Our Ref: EN010152

Application by Fenwick Solar Project Limited for an Order Granting Development Consent for the Fenwick Solar Farm

Advice following issue of decision to accept the application for examination

Reference Number
 EN010152/APP/2.4

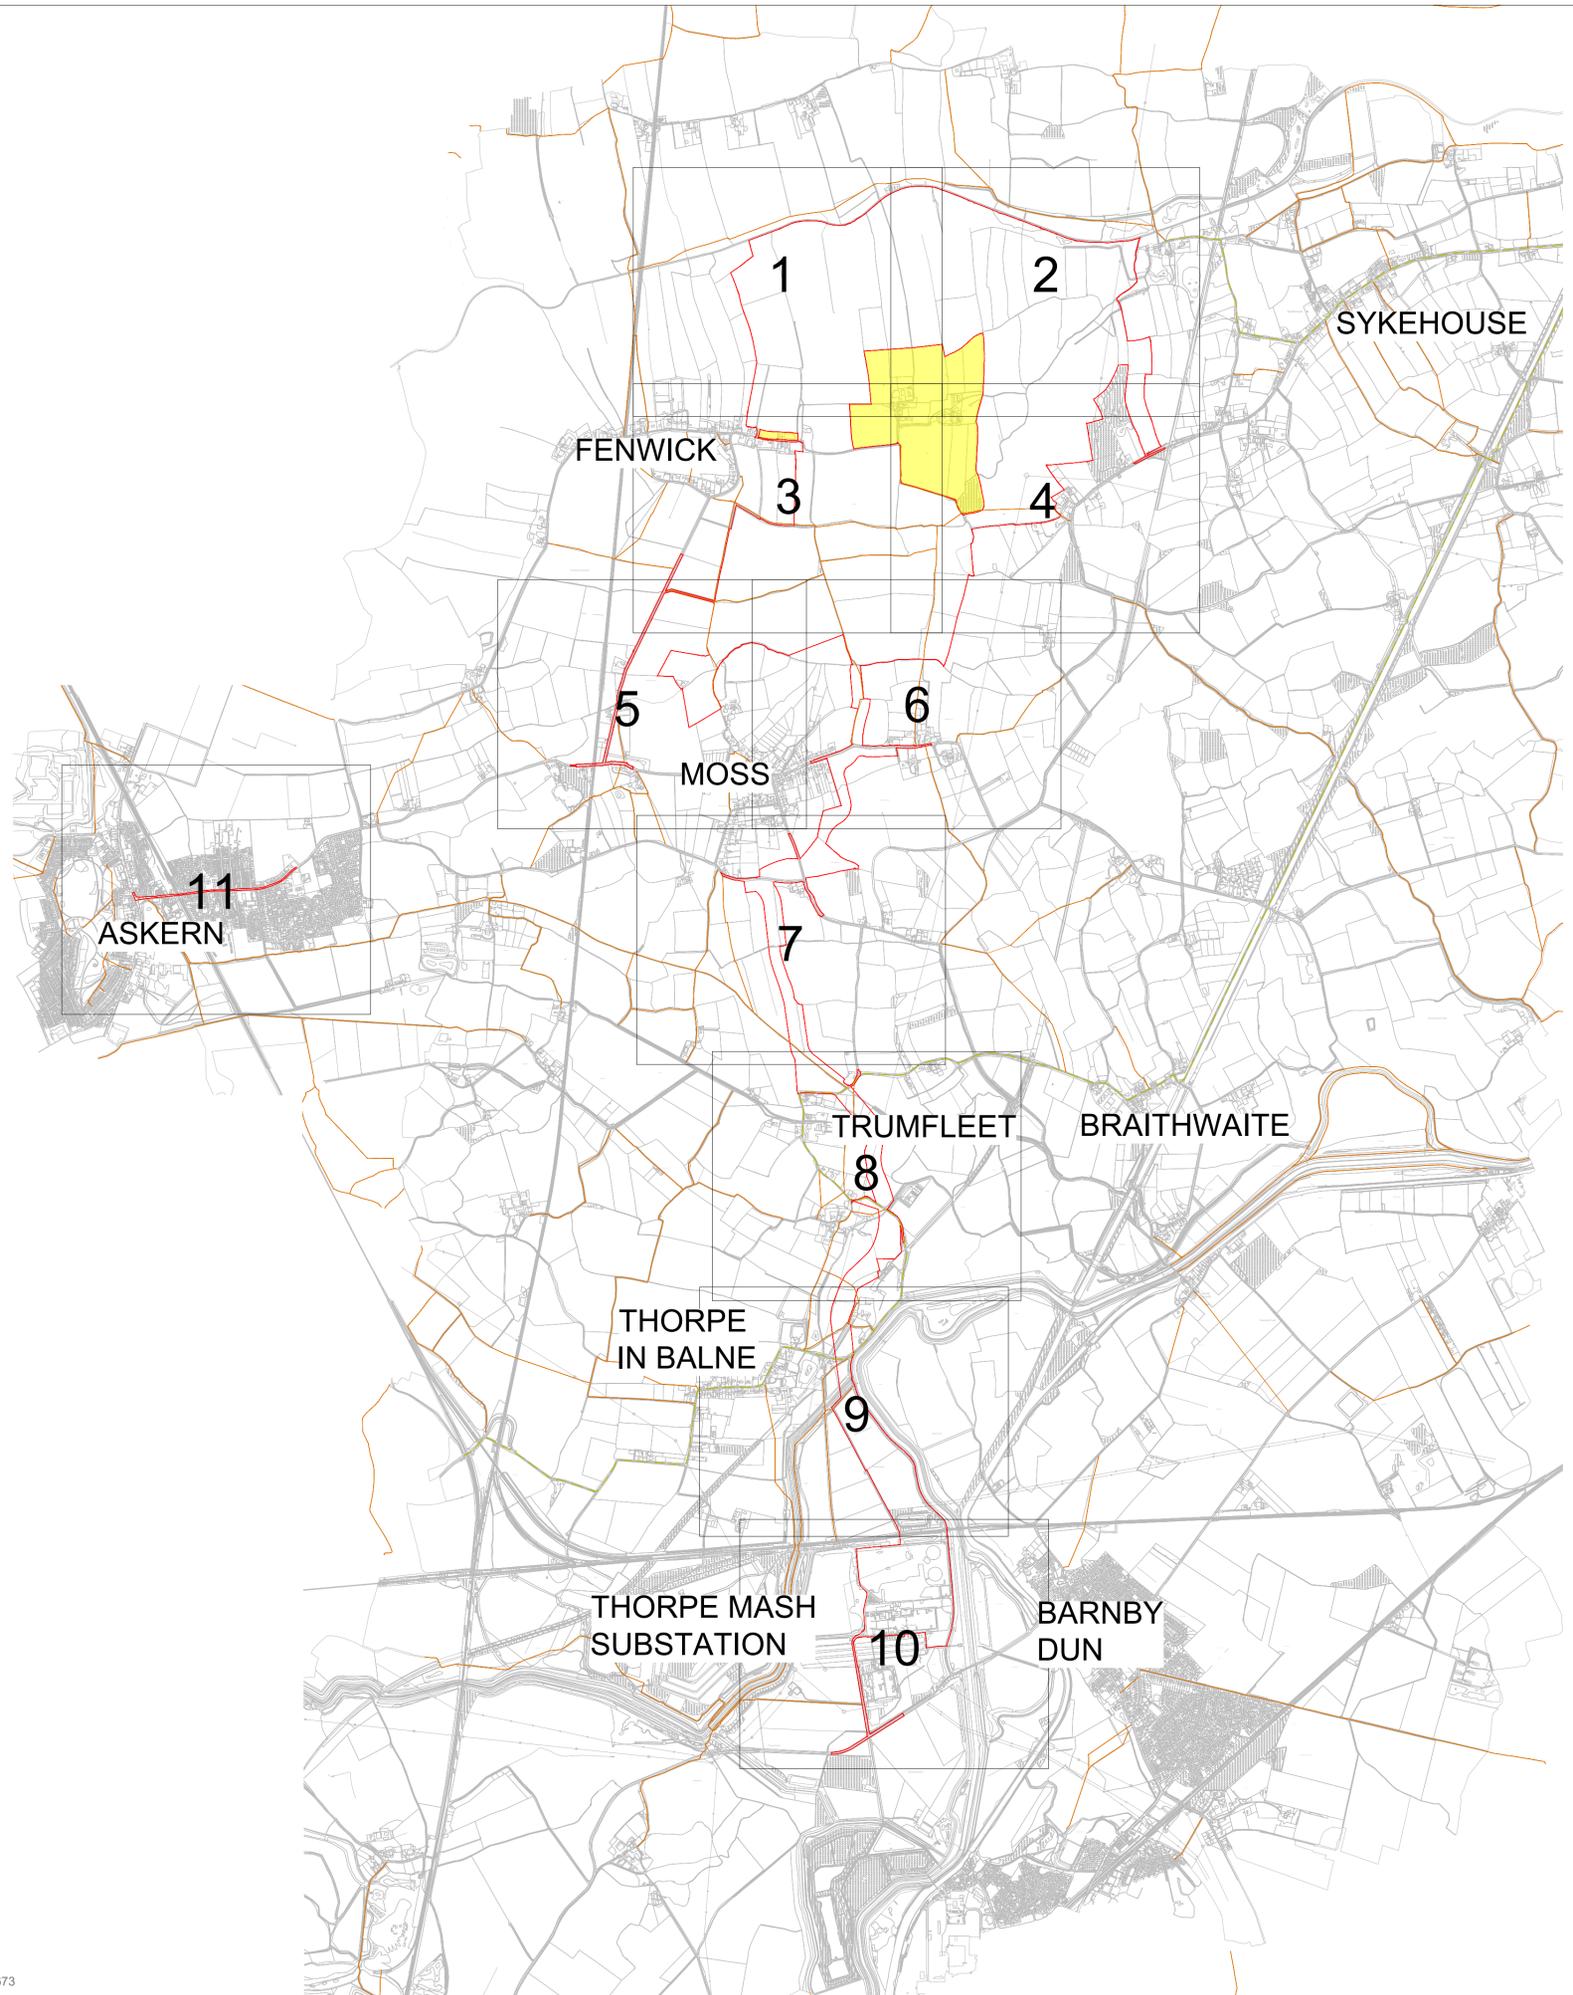
- Streets, Rights of Way and Access Plan (EN010152/APP/2.3) – whilst the document has the correct name, all the plans are incorrectly numbered as EN010152/APP/2.4. Please correct. Additionally, the colour used for ‘*existing access to be retained shown for information only*’ is a shade of green that is difficult to read on the plans. The Applicant is advised to consider a revised colour scheme.

FIGURE NUMBER
Figure 2-4

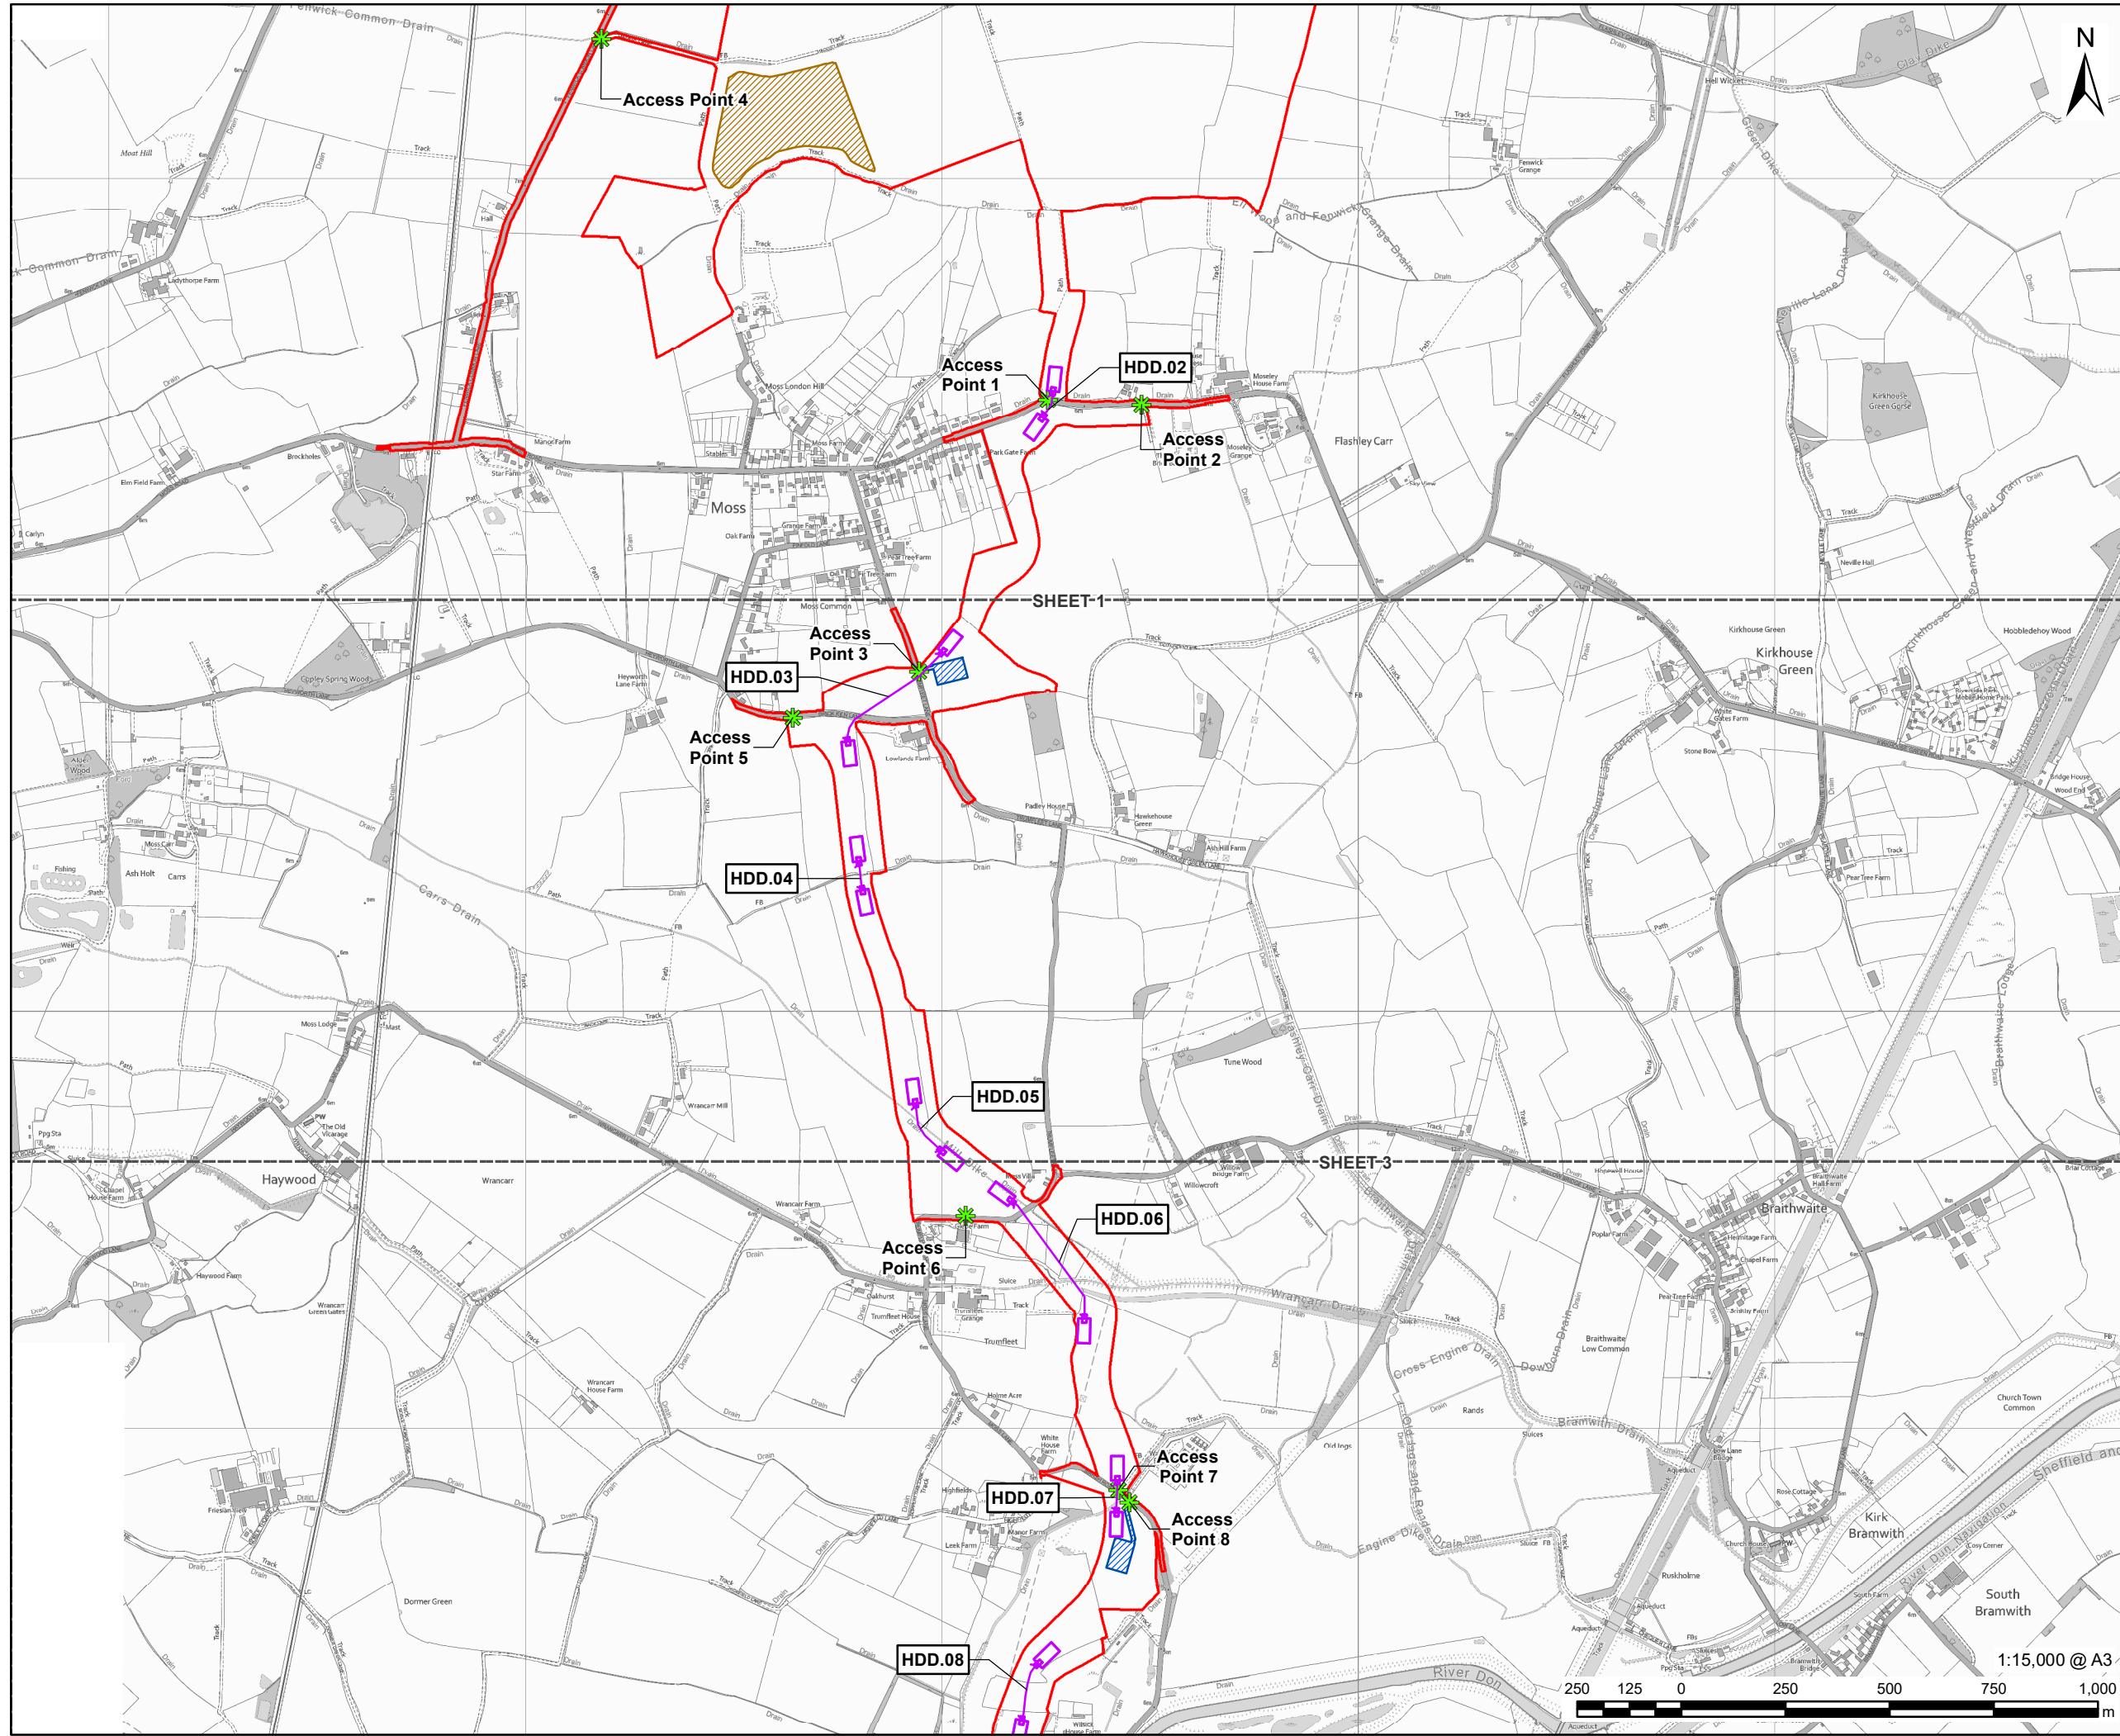
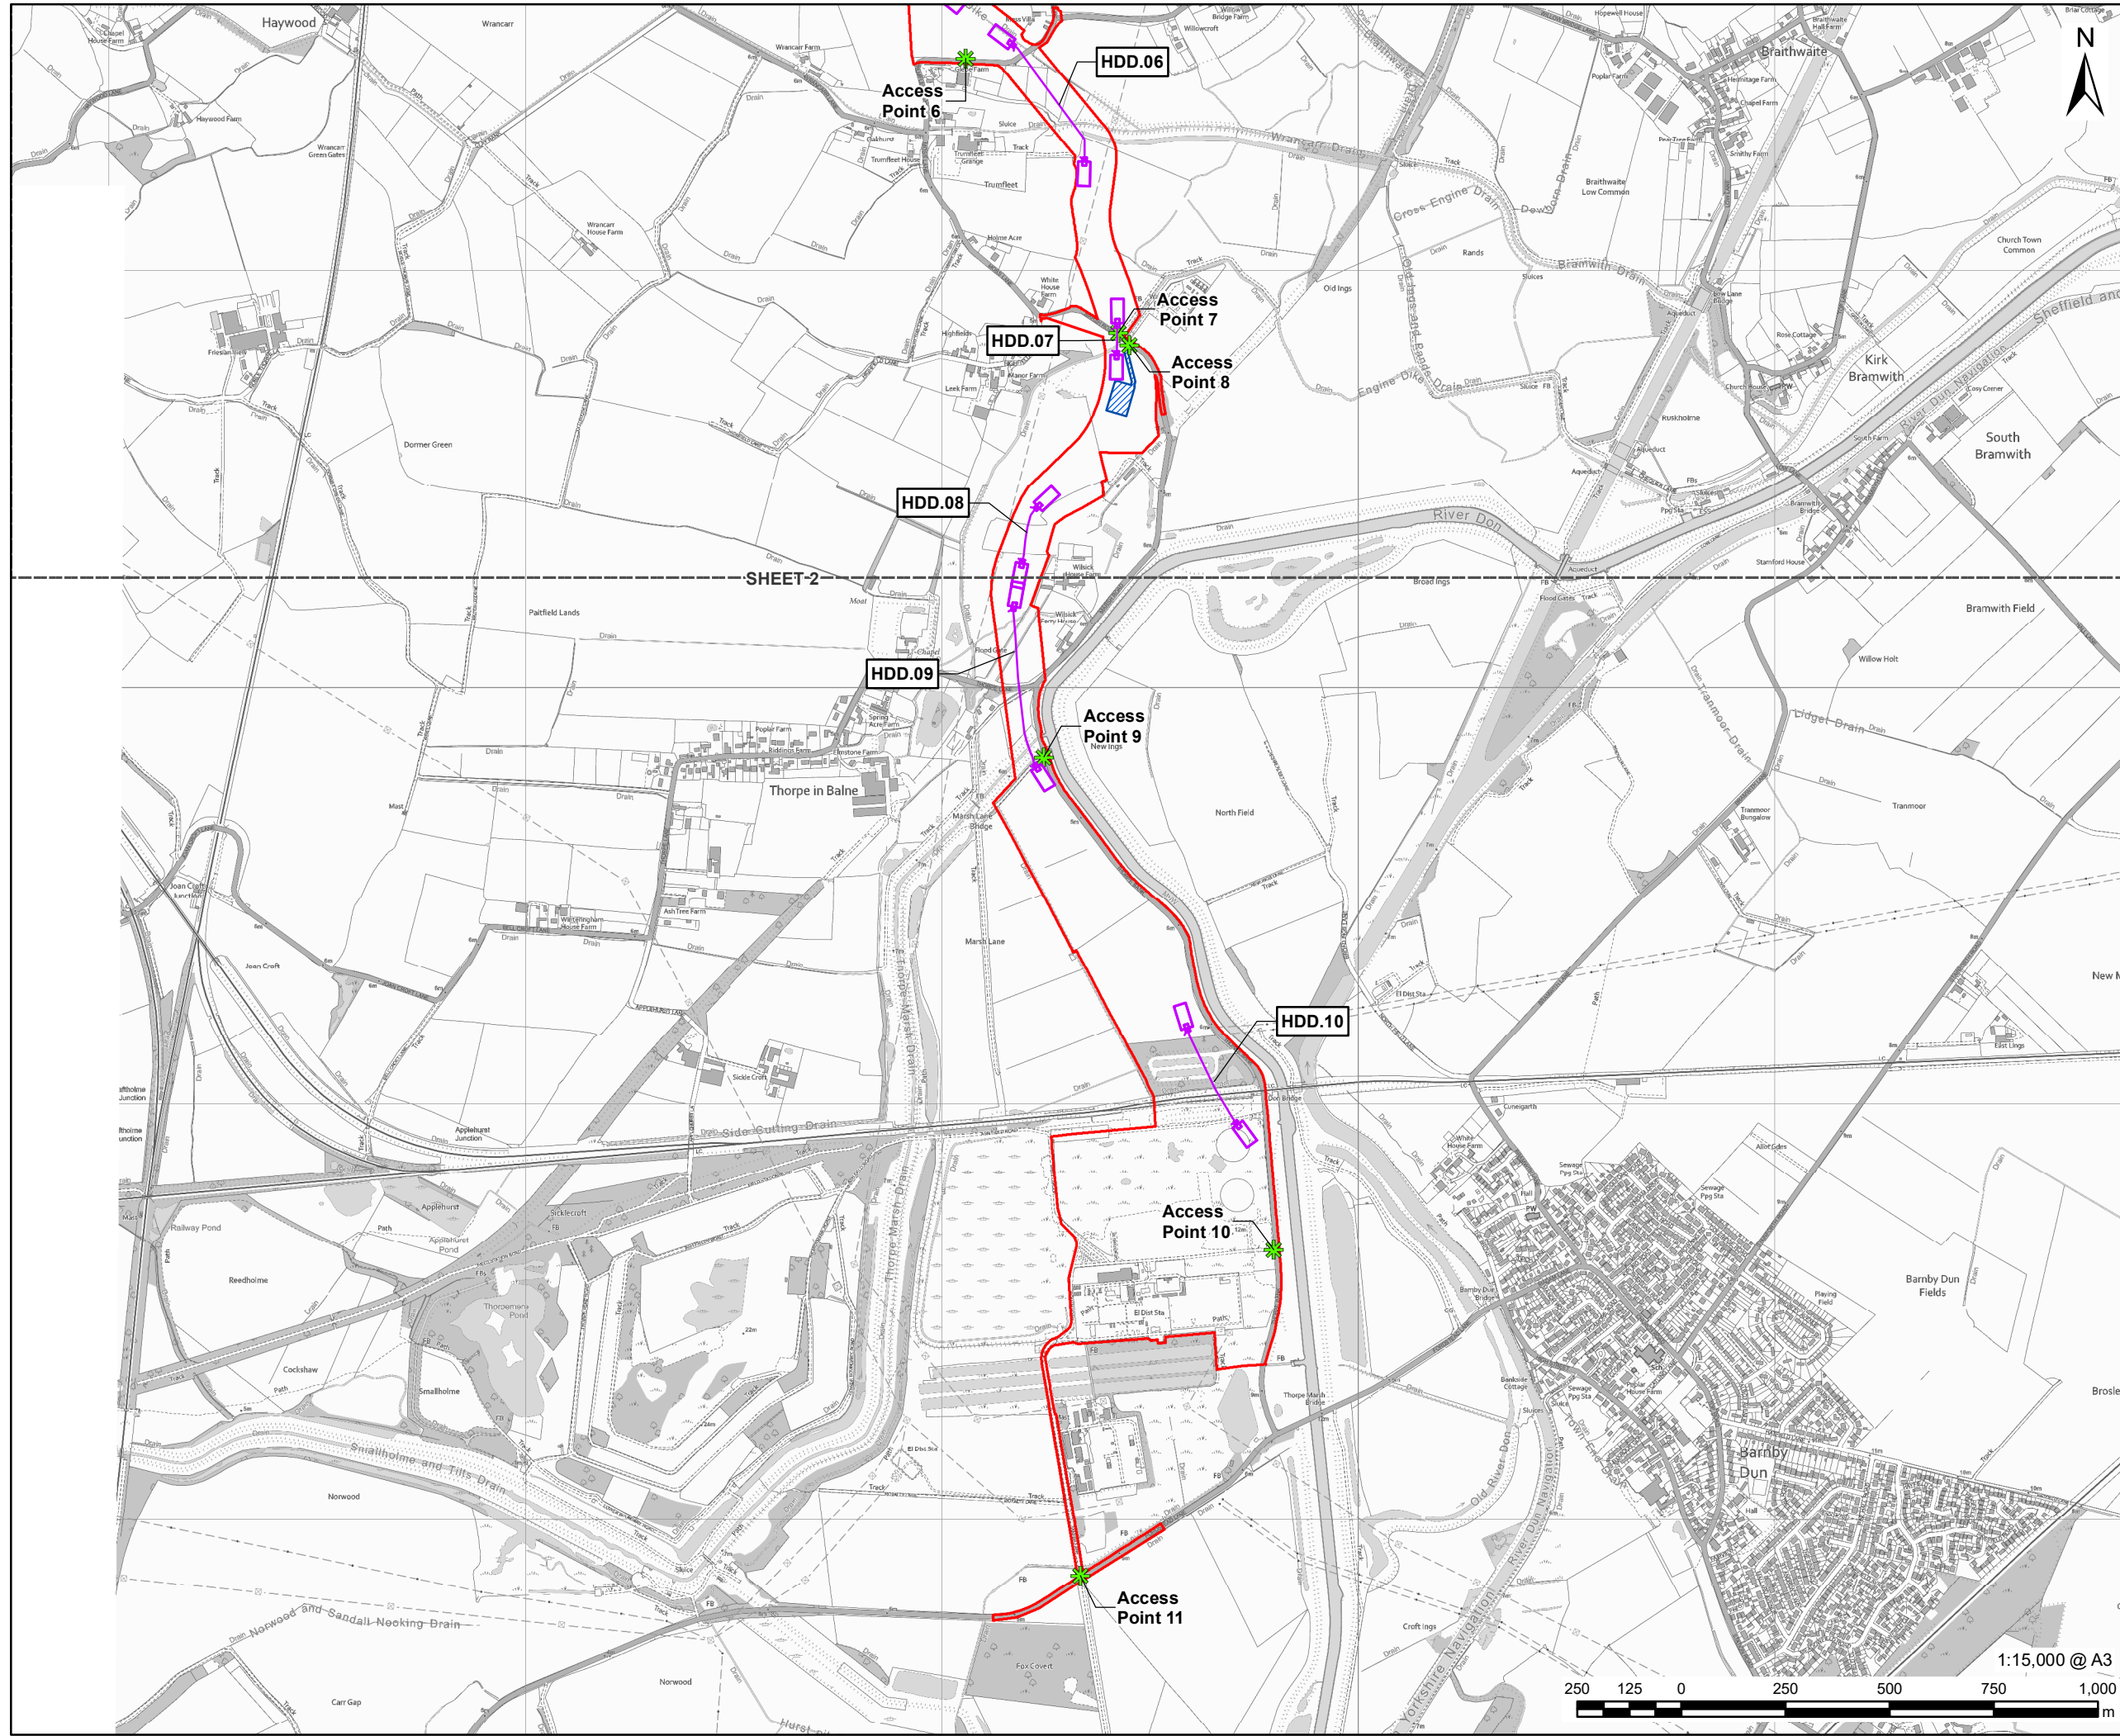
- Paragraph 4.1.3 – this says “*access arrangements to the Grid Connection Corridor are as follows, with access details also shown in ES Volume II Figure 2-4: Location of Temporary Construction Compounds and Indicative HDD Areas [EN010152/APP/6.2]: a. Staff and HGV vehicle movements: i. 100% of all staff and HGV movements will enter/exit via Trumfleet Lane (South of Moss)/Marsh Road/Thorpe Bank.*”. However, the Indicative HGV Routing Figure 13-3 (Doc ref: EN010152/APP/6.2) shows HGV routing via Moss Lane only and no other HGVs travelling south of that. It is therefore unclear how HGVs associated with the cable corridor would access Access Points 6 – 10. The Applicant is requested to provide further clarification on HGV access along the cable route as other documents (including the Transport Assessment) refer to accesses via Trumfleet Lane, Marsh Road and Thorpe Bank and how this aligns with Figure 13-3.
